WELWYN HATFIELD BOROUGH COUNCIL – DEVELOPMENT MANAGEMENT
DELEGATED REPORT

APPLICATION No:	S6/2012/0671/FP
------------------------	------------------------

The application seeks a slight modification of the design of one of the units as granted in 2005. The change comprises a slight movement of the B1 unit to the north by approximately 500mm, provision of a balcony linking this building to the adjoining one to the east and slight modification to the external appearance with a bike store.

CLIENT: THE GA/COYNE CECIL ESTATE  
 JOB: DUNHAM'S COURTYARD  
 DATE: JAN-2002 SCALE: 1:100 eaz  
 DRAWING TITLE: PROPOSED LINK UNIT 17  
 1<sup>ST</sup> FLOOR PLAN - SECTION  
 DRAWING NUMBER: 576-17-SK15A

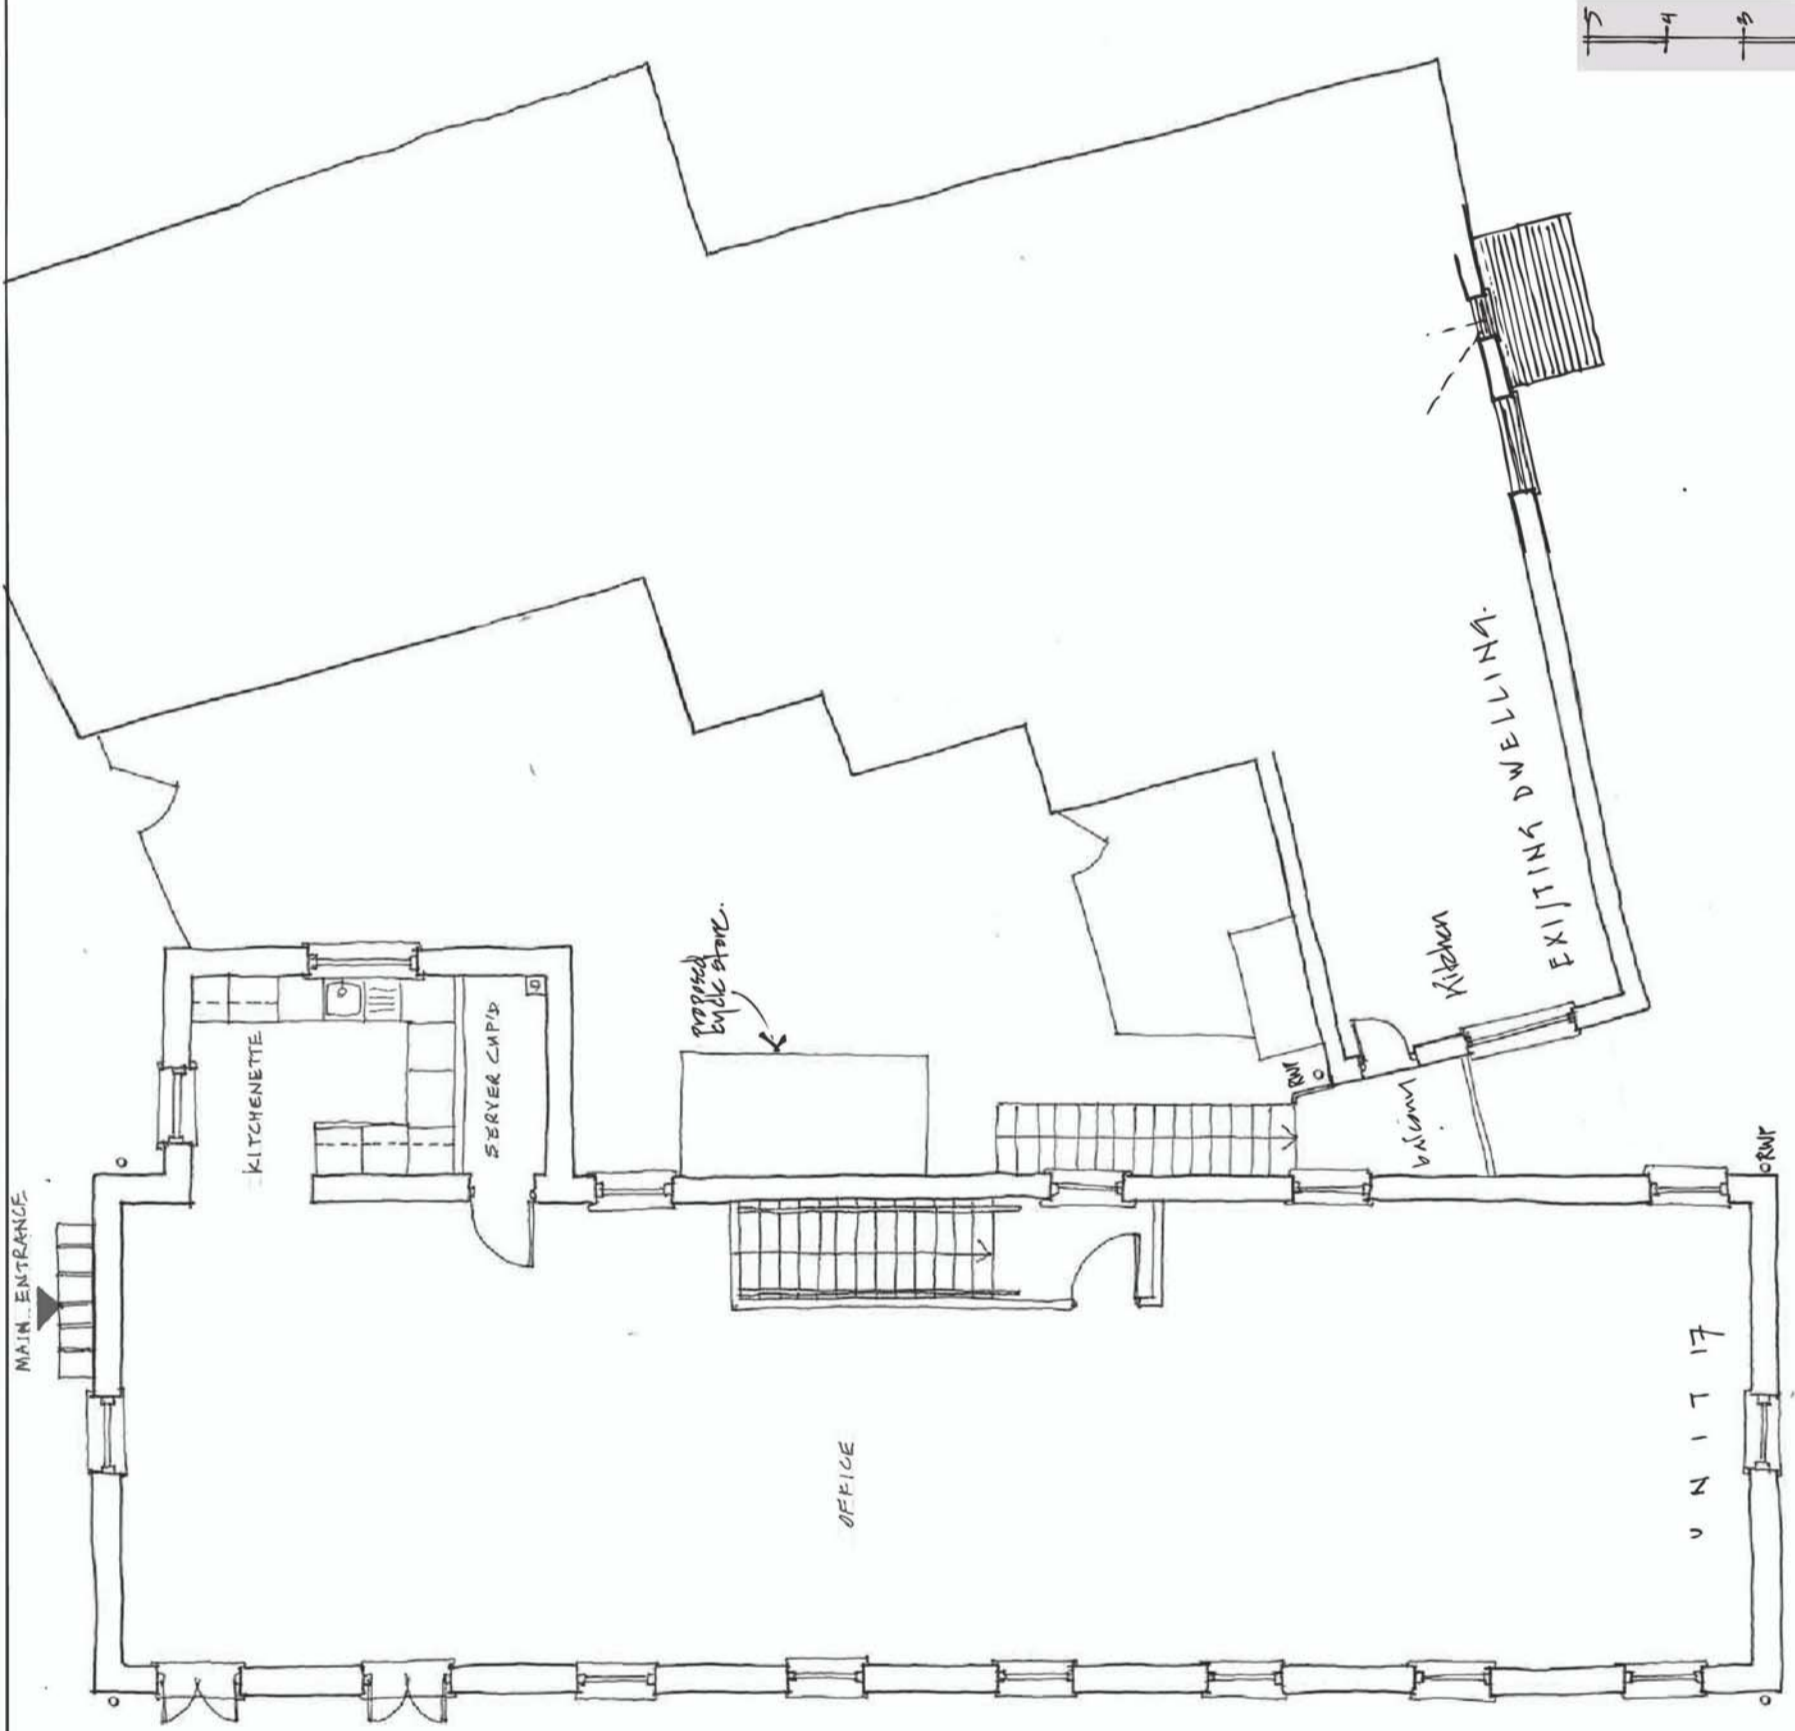
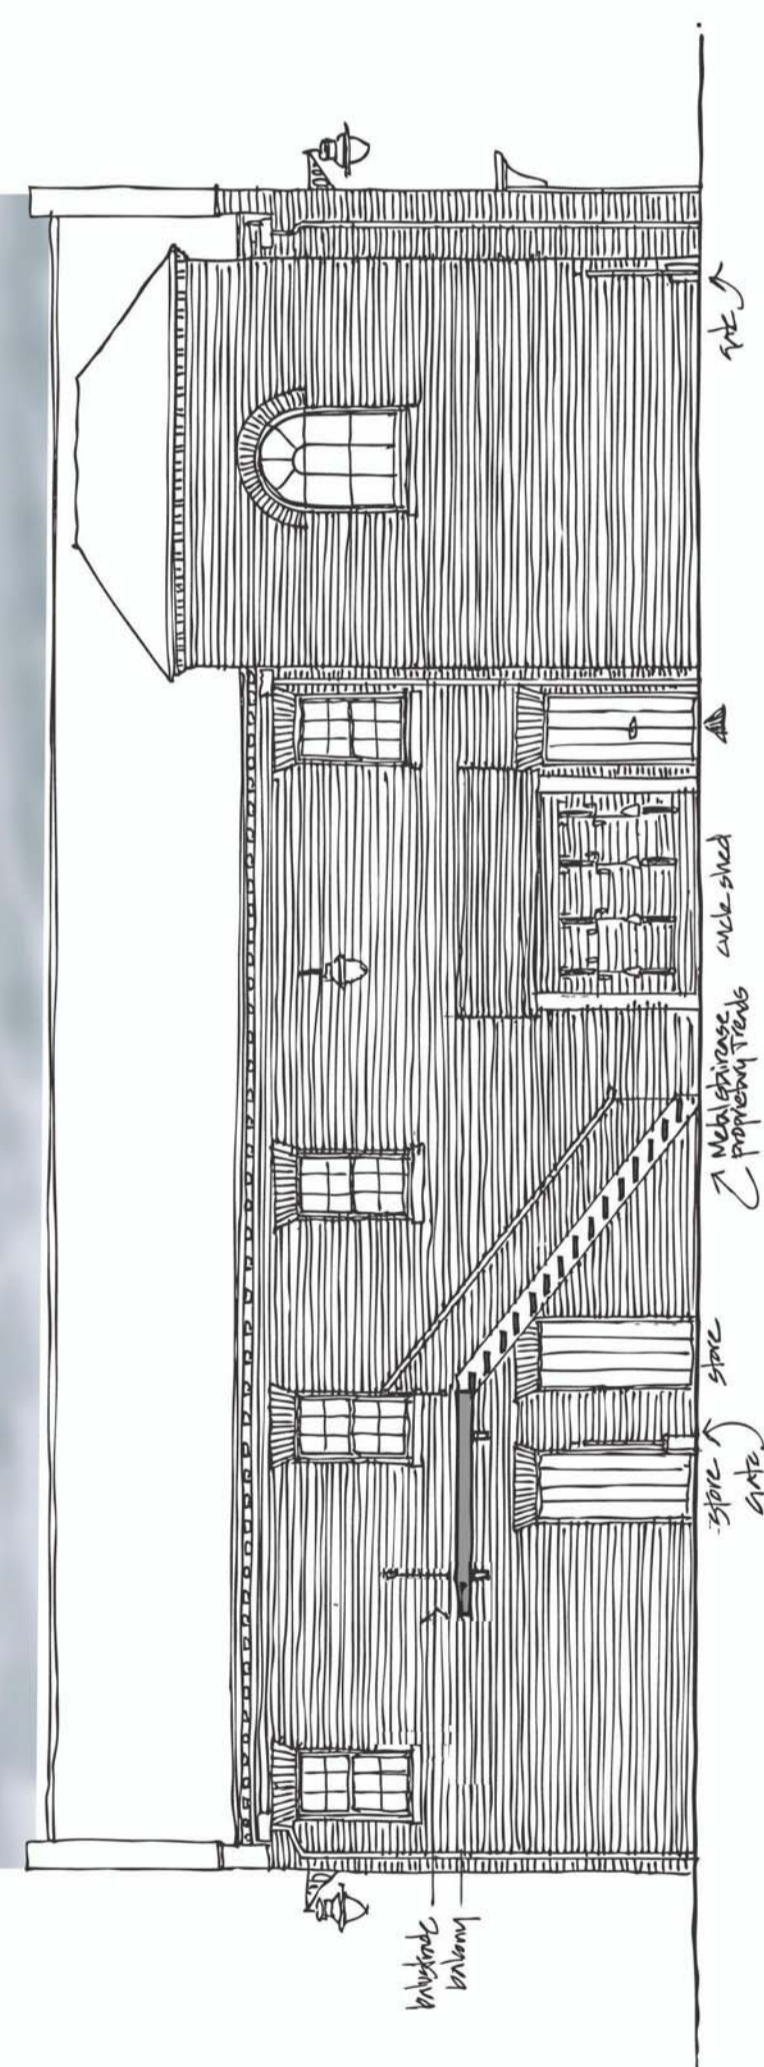
The design changes include the provision of a balcony/fire escape between the proposed building and the adjoining existing building on Park Lane. The fire escape is for the benefit of the existing dwelling 41 Park Street. The fire escape would pass a window in the proposed building, however as this is to be used as an office, it would not lead to undue loss of amenity.

There would be the potential of people standing on the balcony and looking towards existing buildings to the south. The balustrade/balcony area has been amended during the course of the application to set this away from the nearest property to the south of this development. The separation distance is now sufficiently far away to ensure that any perceived overlooking from people using the fire escape/balcony to access this existing dwelling is minimised. It is now considered that there would be no harm to existing occupiers and therefore compliance with policy.

CLIENT: THE GA/LYNE COOL ESTATE	
JOB: DUNHAM COURTYARD	
DATE: JAN-2012	SCALE: 1:100 & 1:200
DRAWING TITLE: PROPOSED LINK UNIT 17 (PLAN - ELEV - PERSPECTIVE)	
DRAWING NUMBER: 52-17-SK02A

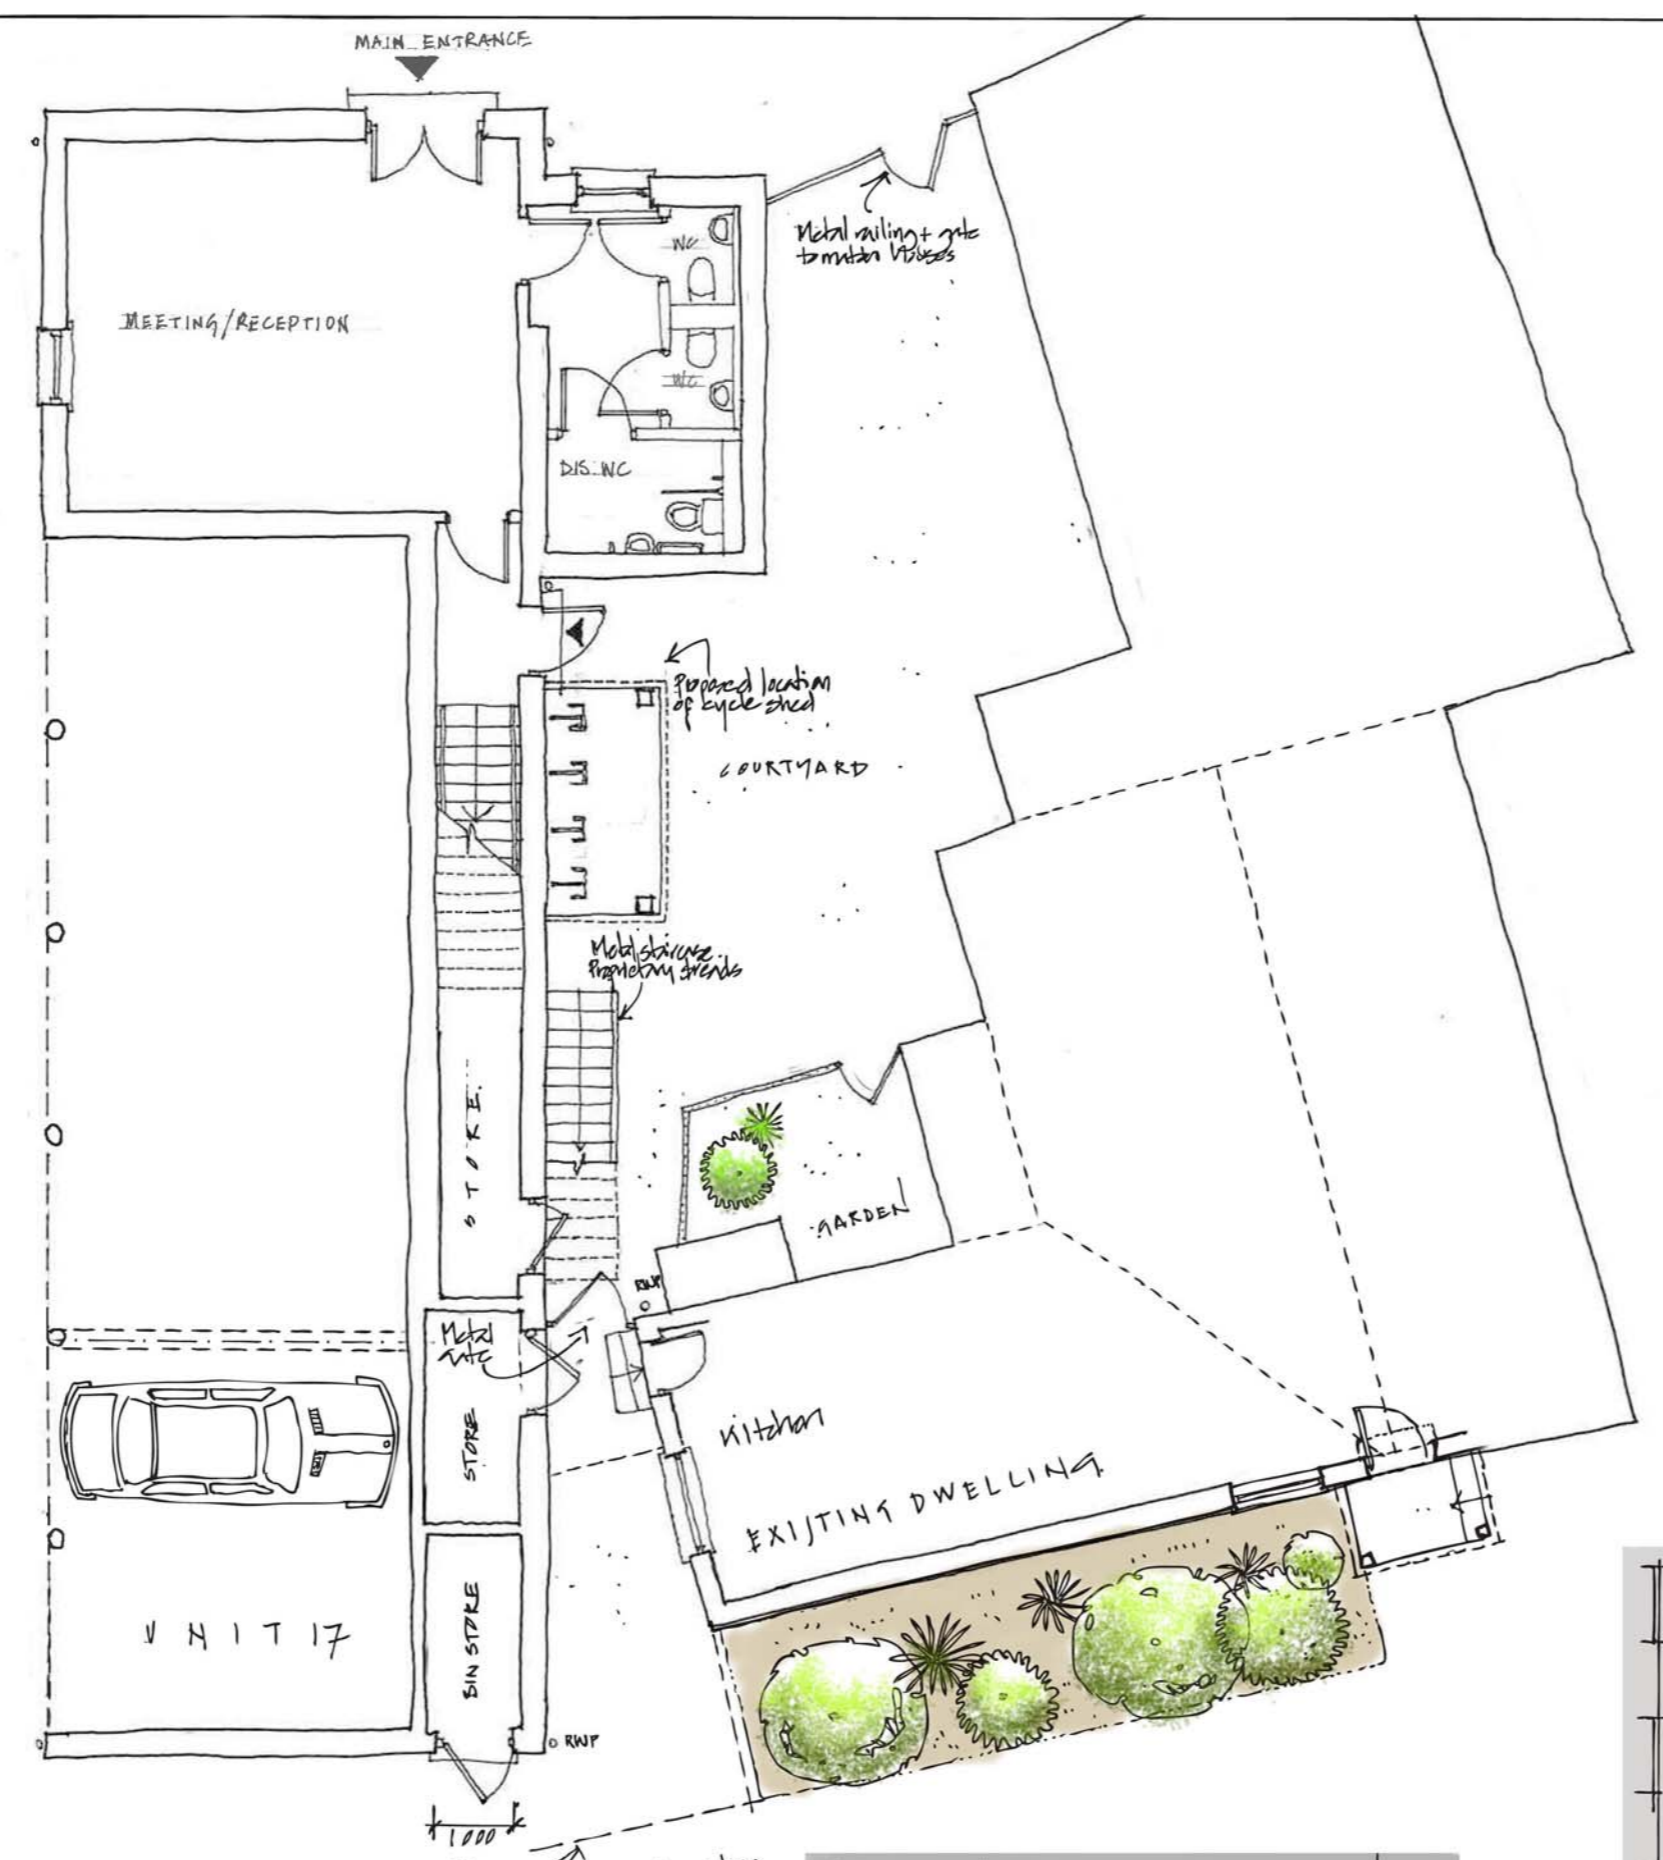
The other alterations comprising the provision of an external bicycle store is acceptable and the design is such that it would reflect the proposed building and would not harm amenity of existing occupiers of the adjoining dwellings.

The proposed alterations would not result in harm to the amenity of adjoining occupiers and the design of the alterations would result in an enhanced development. The scheme has been amended to overcome original concerns regarding the siting of the balcony. A s106 deed of modification is being completed to secure this amended permission as part of the original scheme.
